# Memorandum

**Re:** Harvey Industries, 401 Riverside St. (313 F039) app#030147

A review of the submissions for the above permit is partially complete. I have the following questions/comments:

1 PLAN
SCALE: 1/4" = 1'-0"

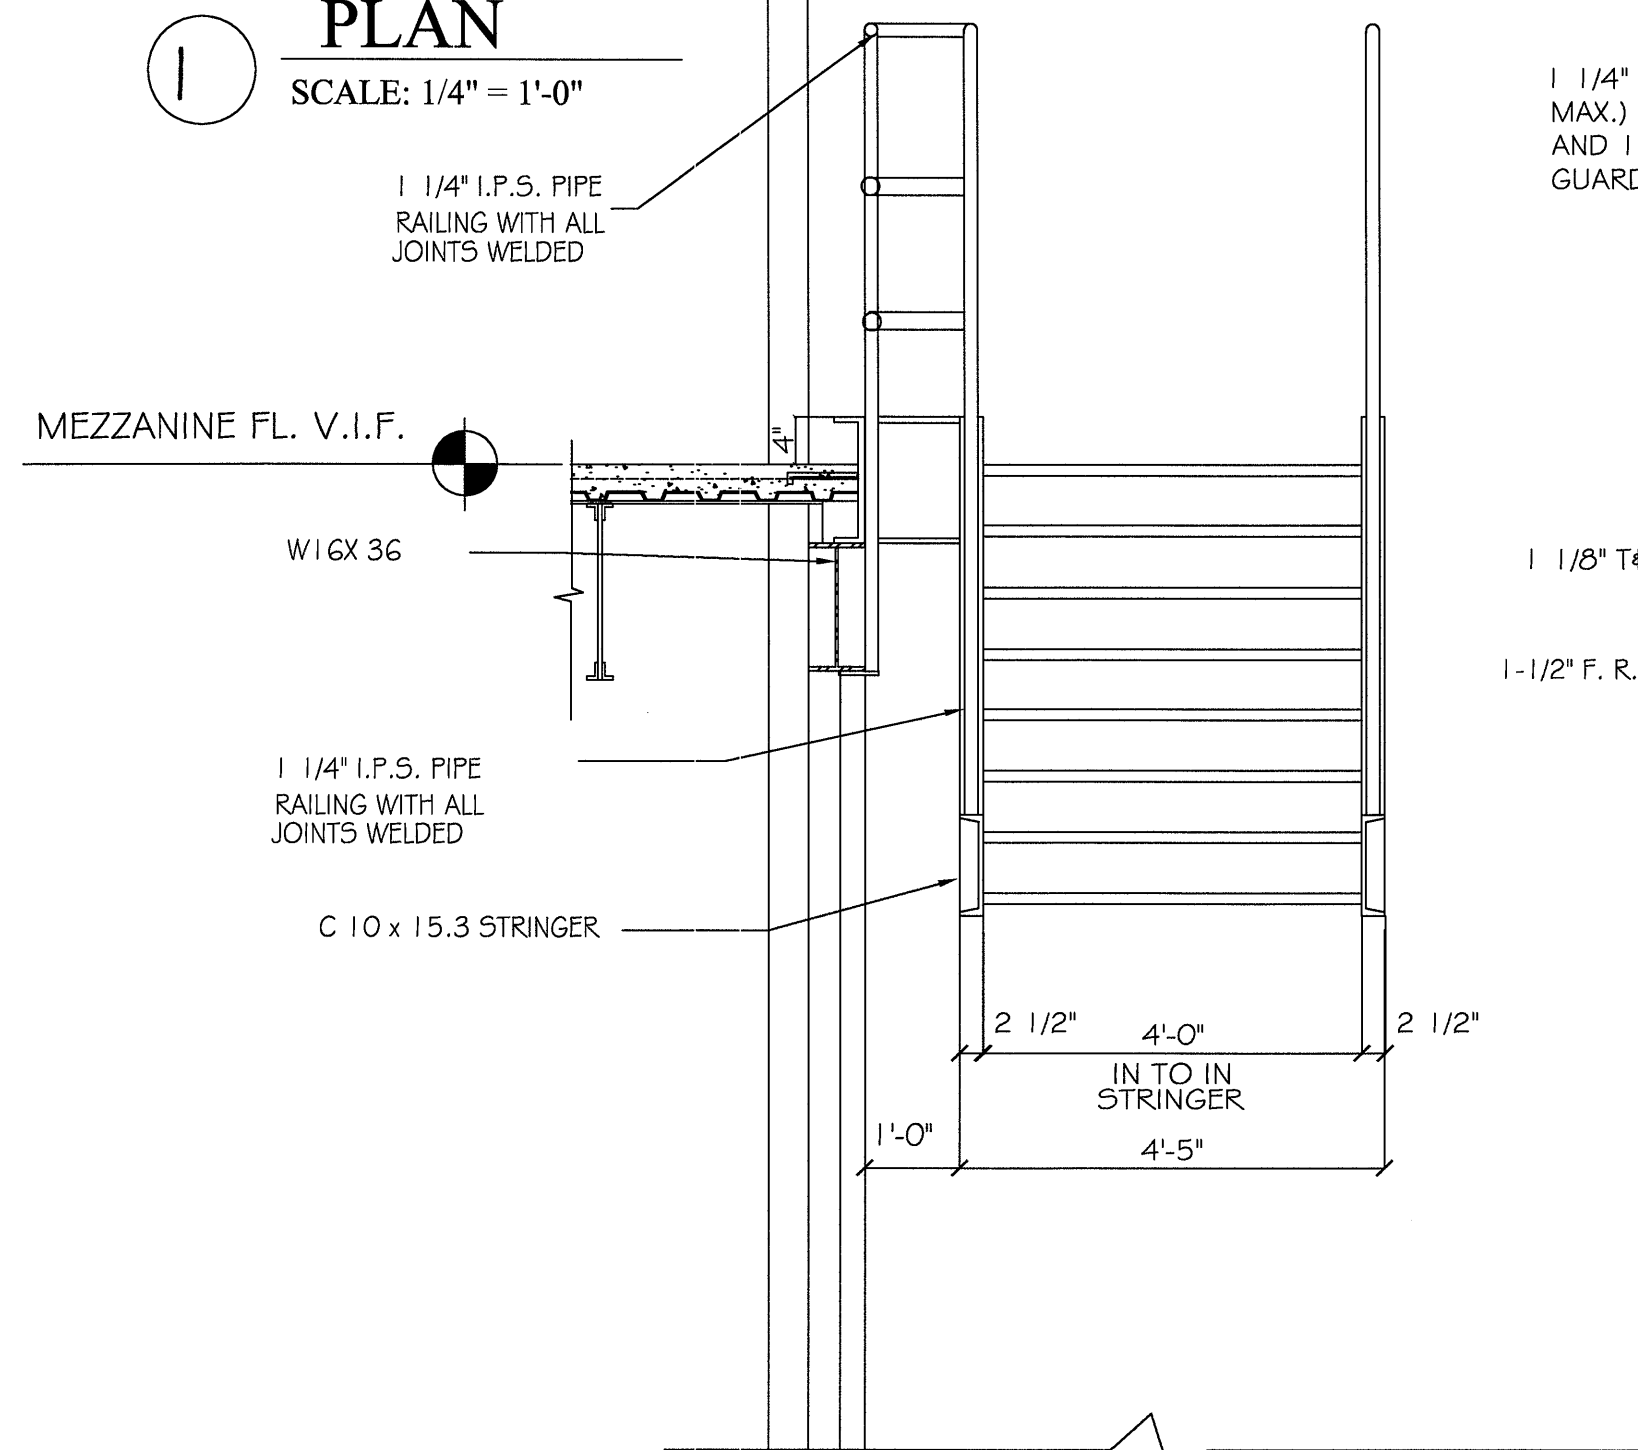
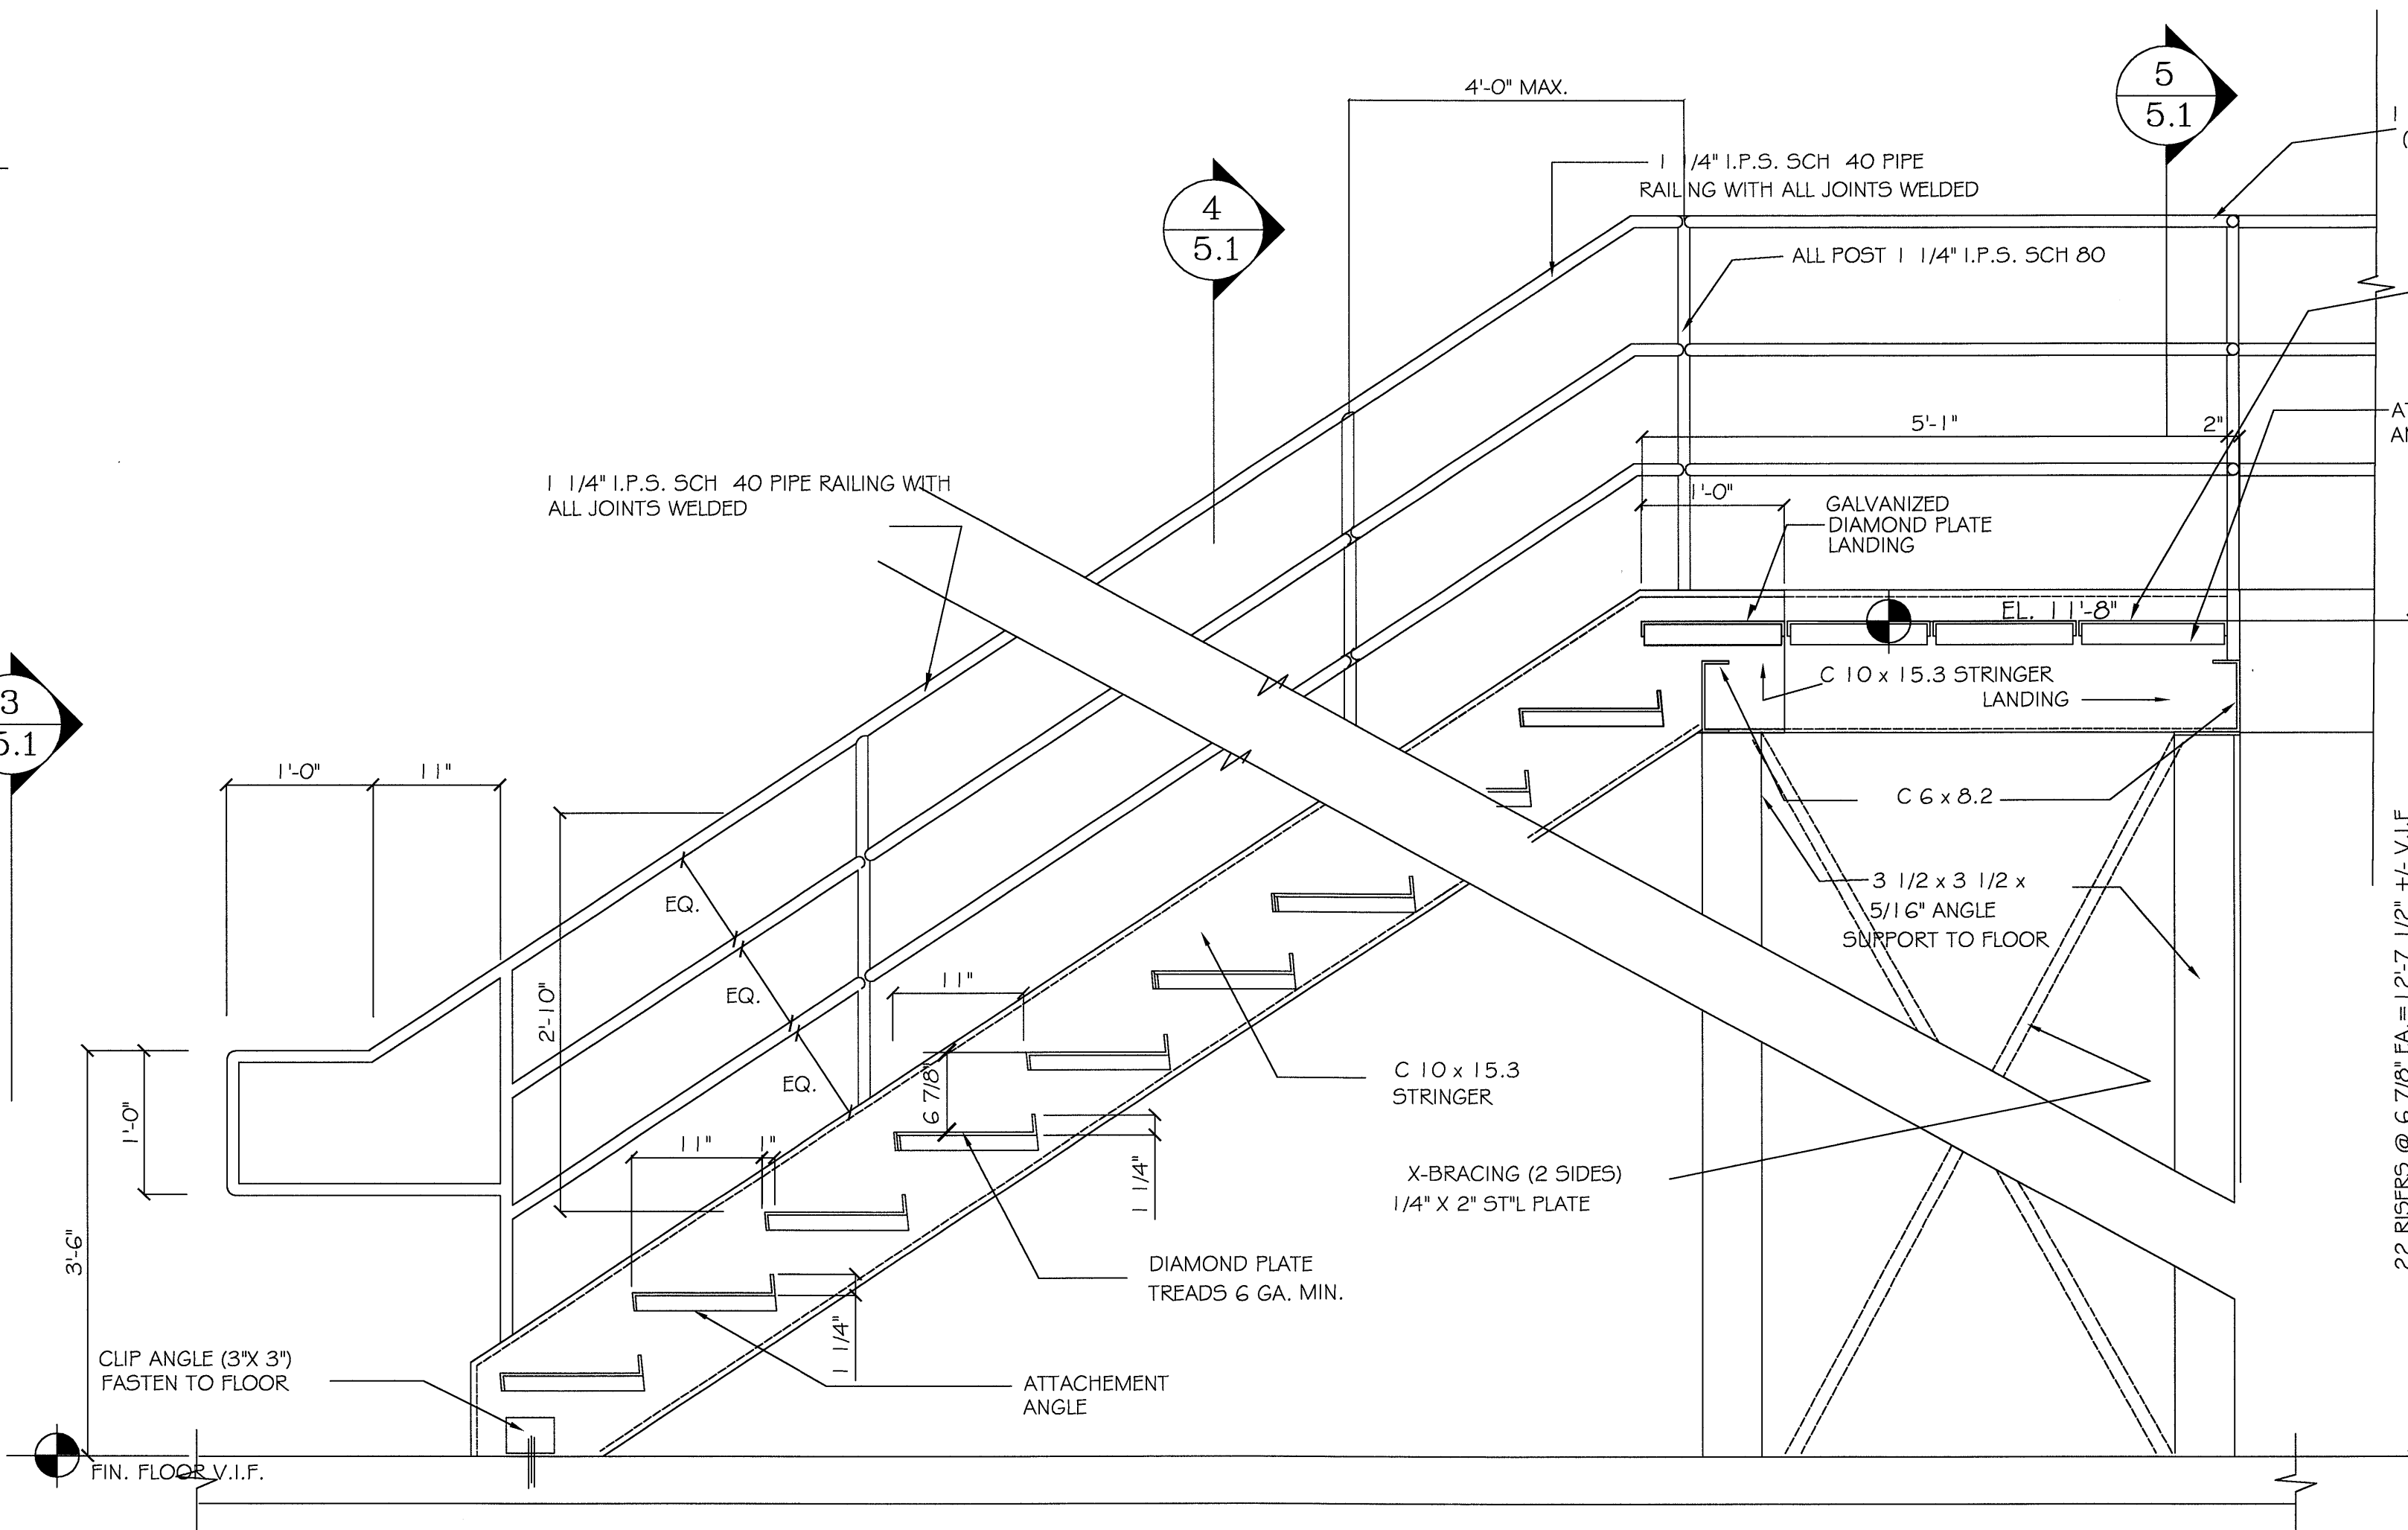
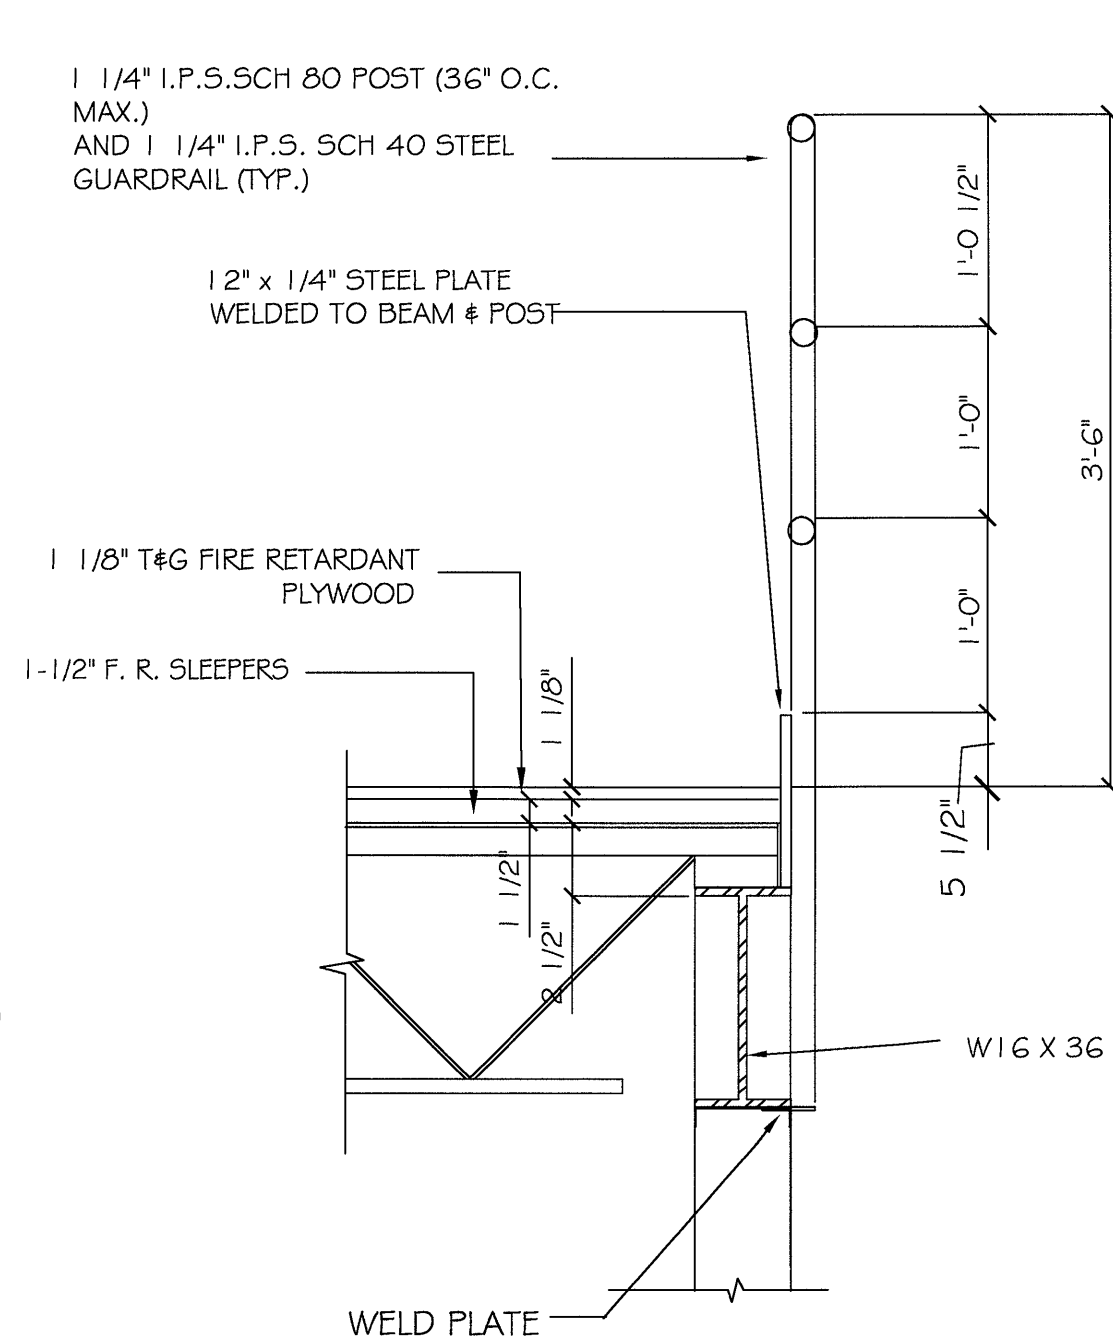
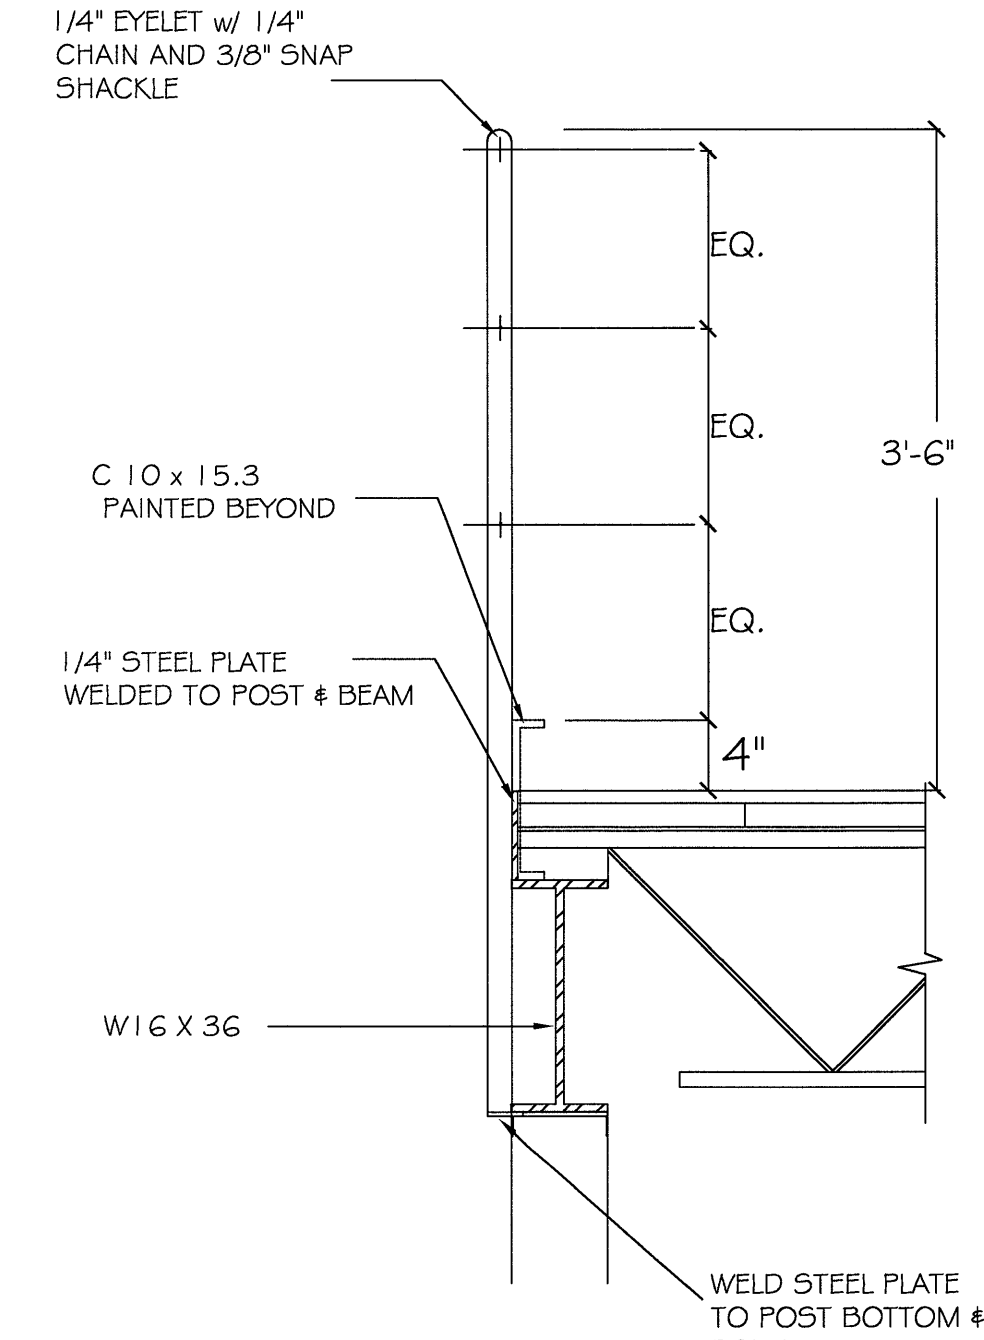
- 1) Roof Snow Load is shown as 35 psf, please explain the methodology.
- 2) The S1 use group is not proposed to be fire separated from the from the B/M use group and it exceeds 10% of the floor area, Please provide a code justification. (see Section 302.1.2).
- 3) Please explain why the break room (mezzanine) is not open as required by 505.4.
